Application number: 2026/91314	
What is the application for?:	Erection of detached supported-living dwelling with associated access, parking,
Address of the site or building:	Ash Meadow, East Avenue, Lindley, Huddersfield, HD3 3LW
Postcode:	HD3 3LW

Type of comment: An objection	
Do you wish your comments to be published on the website anonymously?	Yes
Ashmeadow is a fine 1927 Arts and Crafts house by Lunn and Kaye situated in Character Area 6 as defined in Kirklees Council's Edgerton Conservation Area Appraisal with a matching designed garden with features such as banking, walling, trees and rhododendrons, much of which survives to this day. The site proposed for the house is approximately 1.5 metres below the ground level of the house at 2 East Avenue. The intervening ground within the Ashmeadow garden has up to three levels of low walling and banking, this rising over a horizontal distance of about 3 metres to the boundary fence. This area contains numerous tall shrubs and trees, some many decades old, others planted close together in about 1990. The current ground structures successfully support both the boundary itself and the drive and house/garage very close behind at 2 East

title:
 Proposed Driveway Strategy

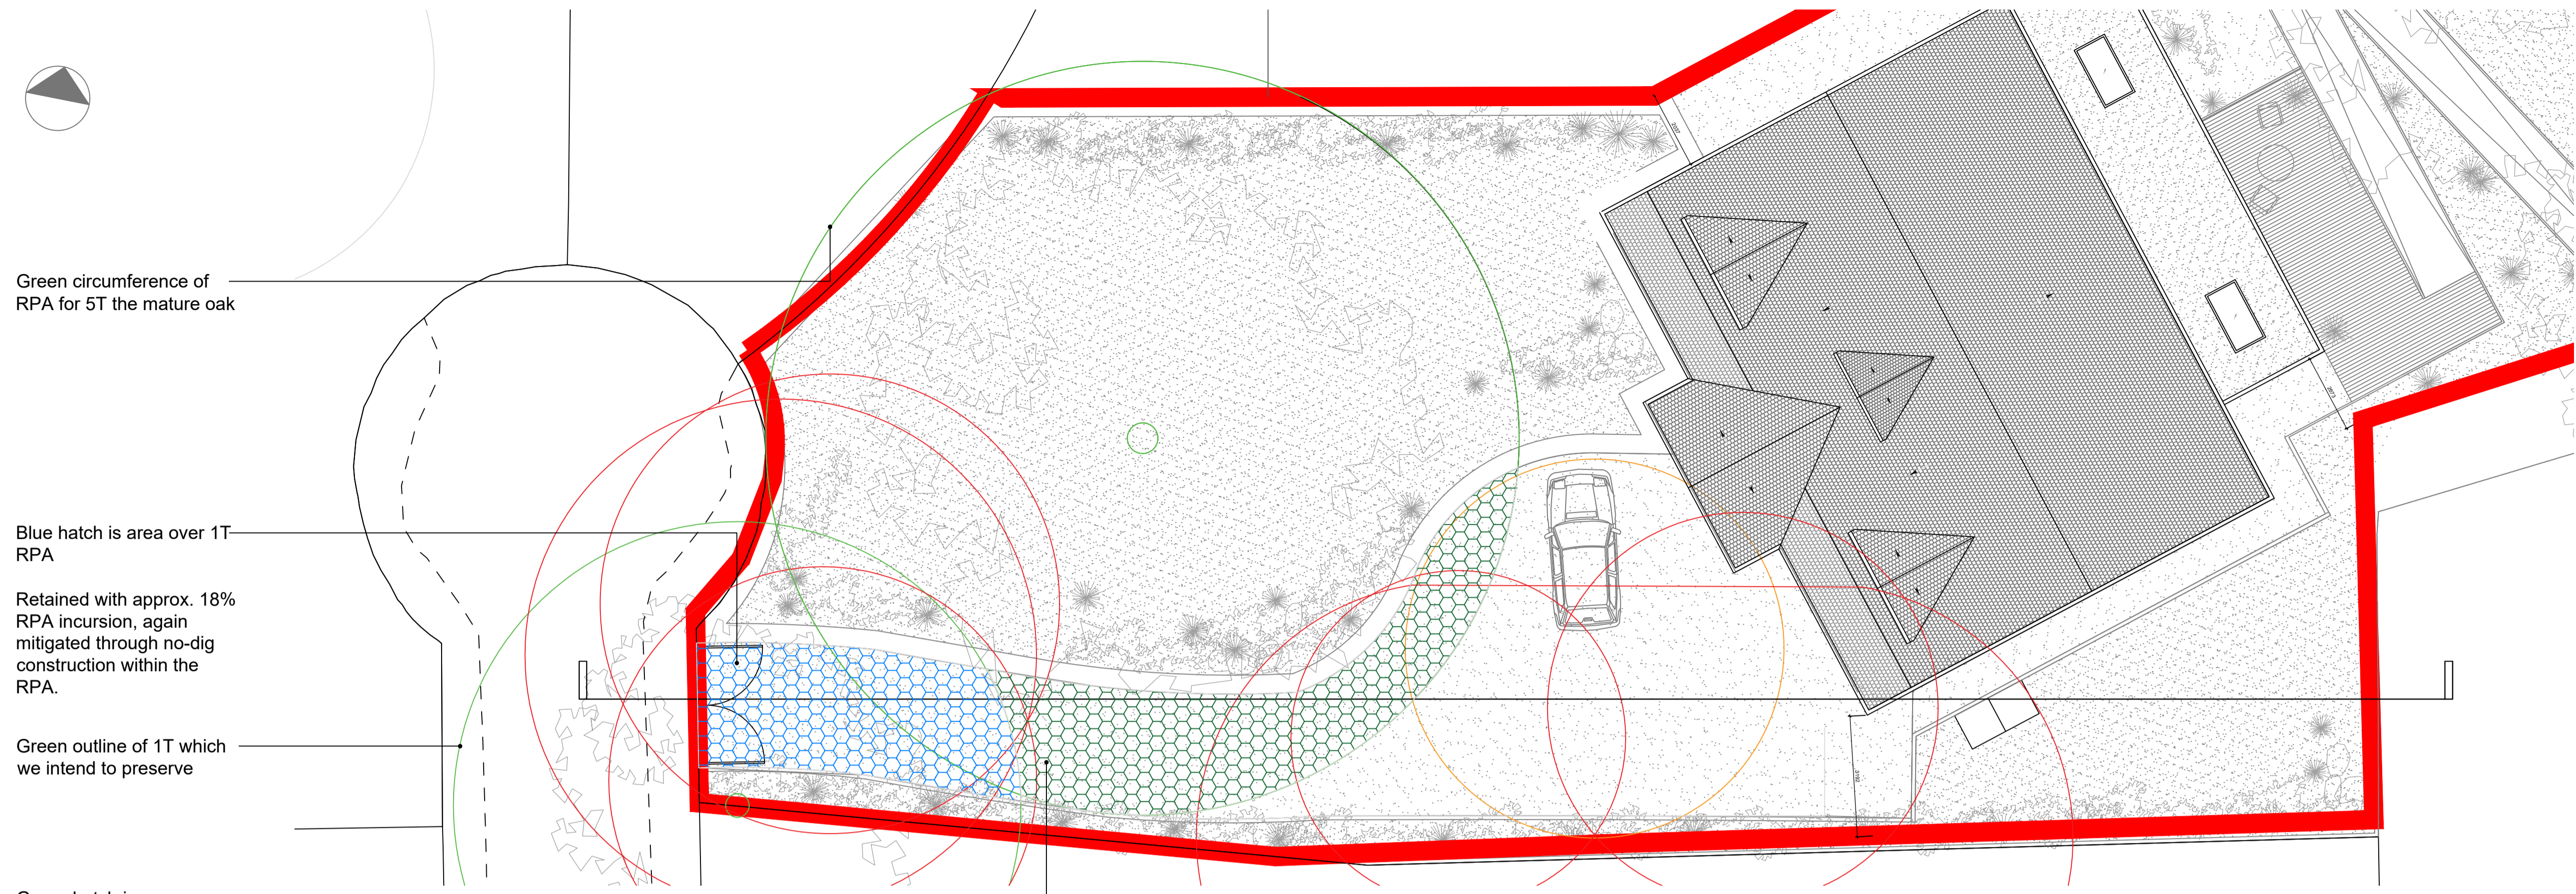
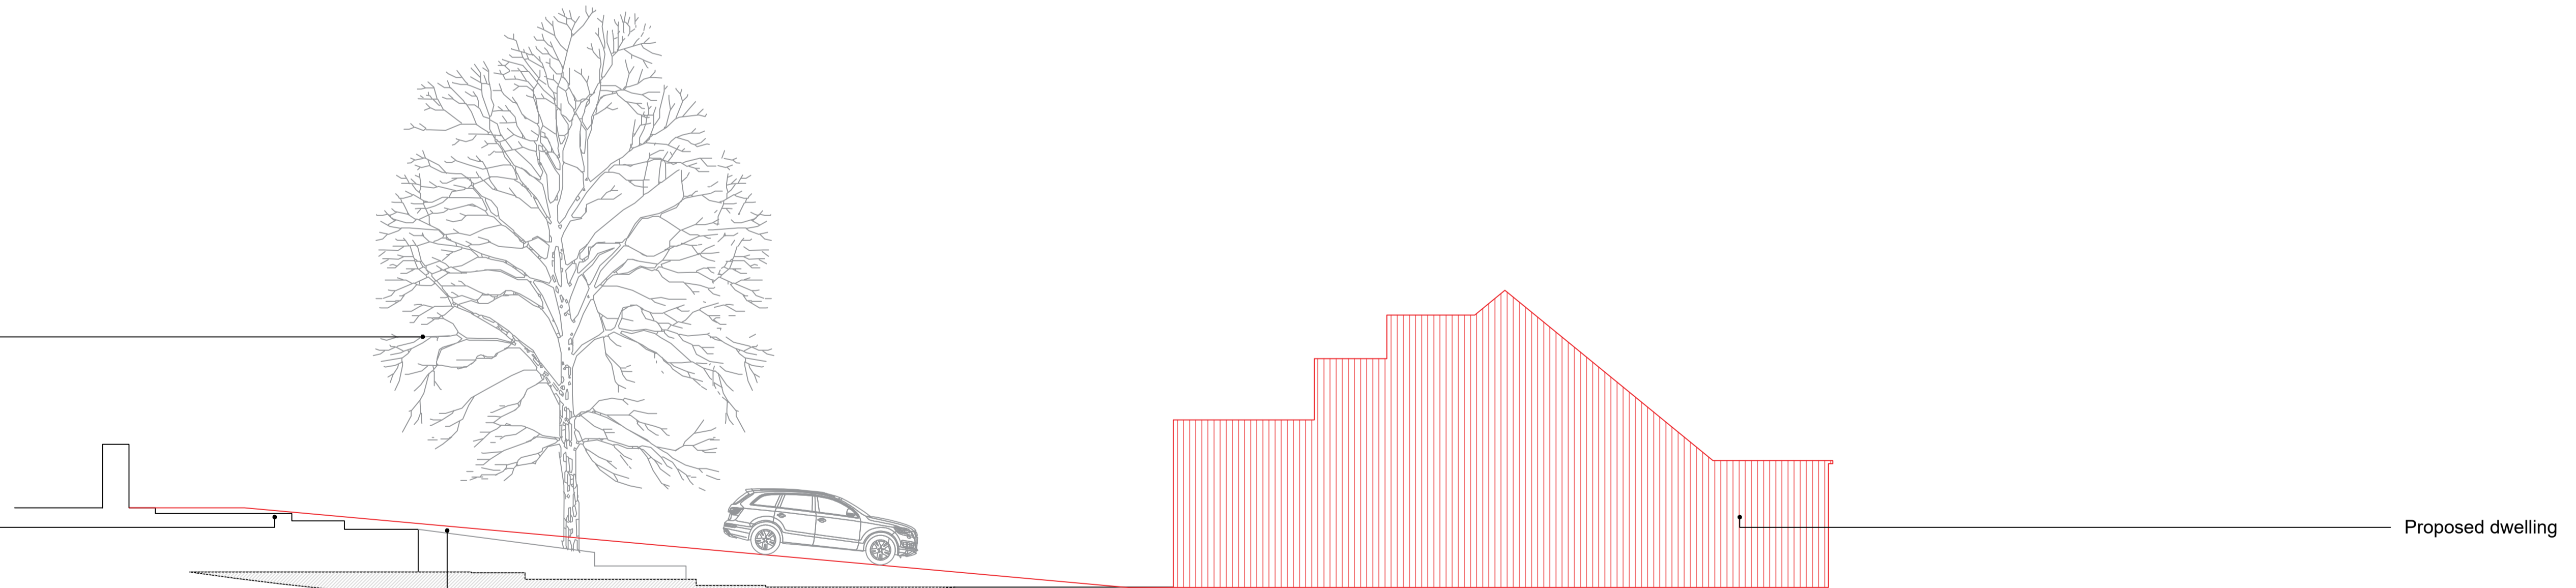
A large mature sycamore tree (1T on the Tree Constraints Plan) forms part of the boundary between 2 East Avenue and this site. It lies within 1 metre of the East Avenue walling and sits on a raised ground level about 30 cm ABOVE the East Avenue road level. Alongside the nearby mature lime tree (2T), this forms part of the delightful roadside tree cover of this part of the Conservation Area. The submitted plan suggests a level entry for the proposed new drive about 1 metre from the boundary at the point of tree 1T.

As this mature tree (1T) on the 2 East Avenue and road boundary must be retained to maintain the character of the conservation area, we are puzzled that the drive is planned to come through what the Tree Constraints Plan shows to be within the 'minimum root protection area' of boundary tree 1T as well as that of nearby tree 2T. Remembering that tree 1T also has a higher ground level base than the road, we ask how a drive can come through here without causing severe, possibly fatal, damage to this tree?

We ask that a plan for the drive entry point be resubmitted which respects both the survival of tree 1T and the use of 'no dig' construction method, as is already proposed for the nearby oak tree 5T. We also ask that any pavement removed is replaced by matched stone setts to maintain the conservation area character, as was done when the drive for nearby 2 East Avenue was constructed in 1992.

Additionally, we can find no mention of how construction of the drive route will impact the internal garden walling features currently in place. If these are to be removed, we ask that a plan be provided as to how will be guaranteed the maintenance of structural stability of the ground immediately to the south against the boundary which, by the point the drive reaches the turning area, will be over 1 meter higher.

Proposed Site & Roof Plan
Scale 1:200

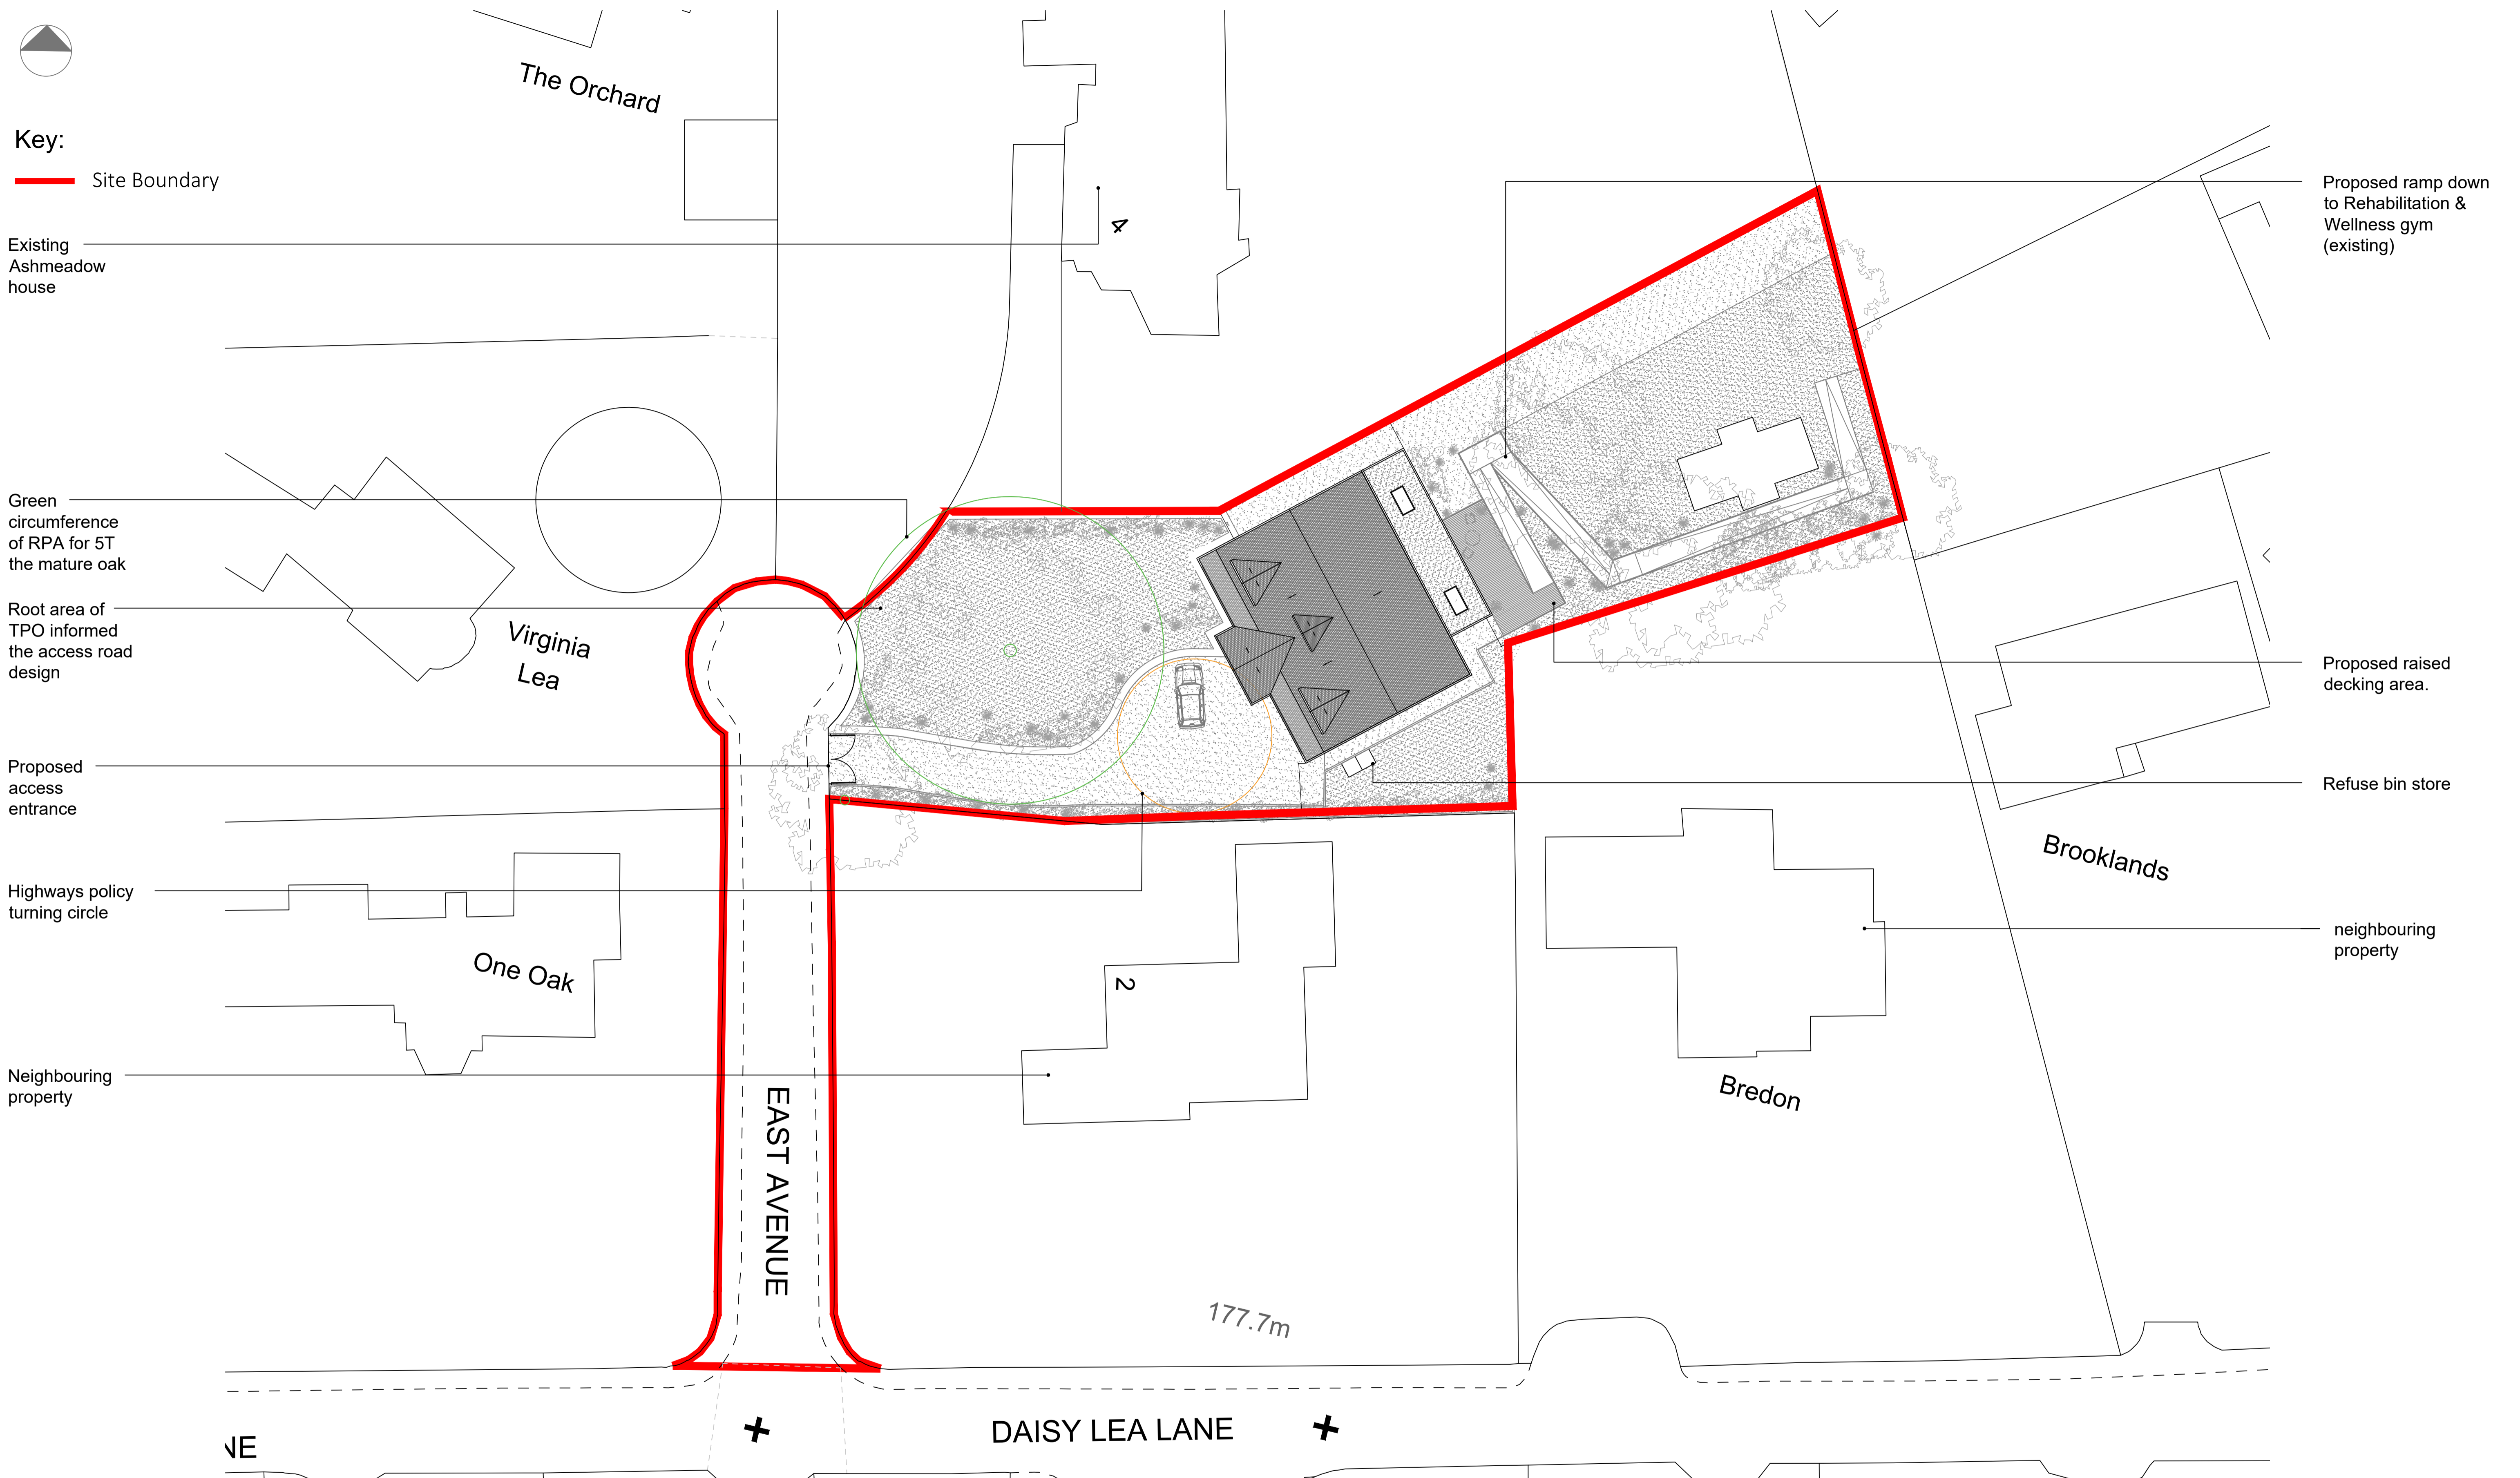
- 3) Lighting along the drive, in the turning area and at the front of the house
– we ask for a condition that any and all lighting in the above areas be directed downwards, so as not to shine above the existing 1-5m high boundary fence across towards 2 East Avenue.
- 4) Precise ground level and position of the house
– we ask for a condition that the house ground level be at the same level as the existing Ashmeadow garden and that its precise ground location be fixed at distances from adjoining existing properties no less than shown on the already submitted plans.
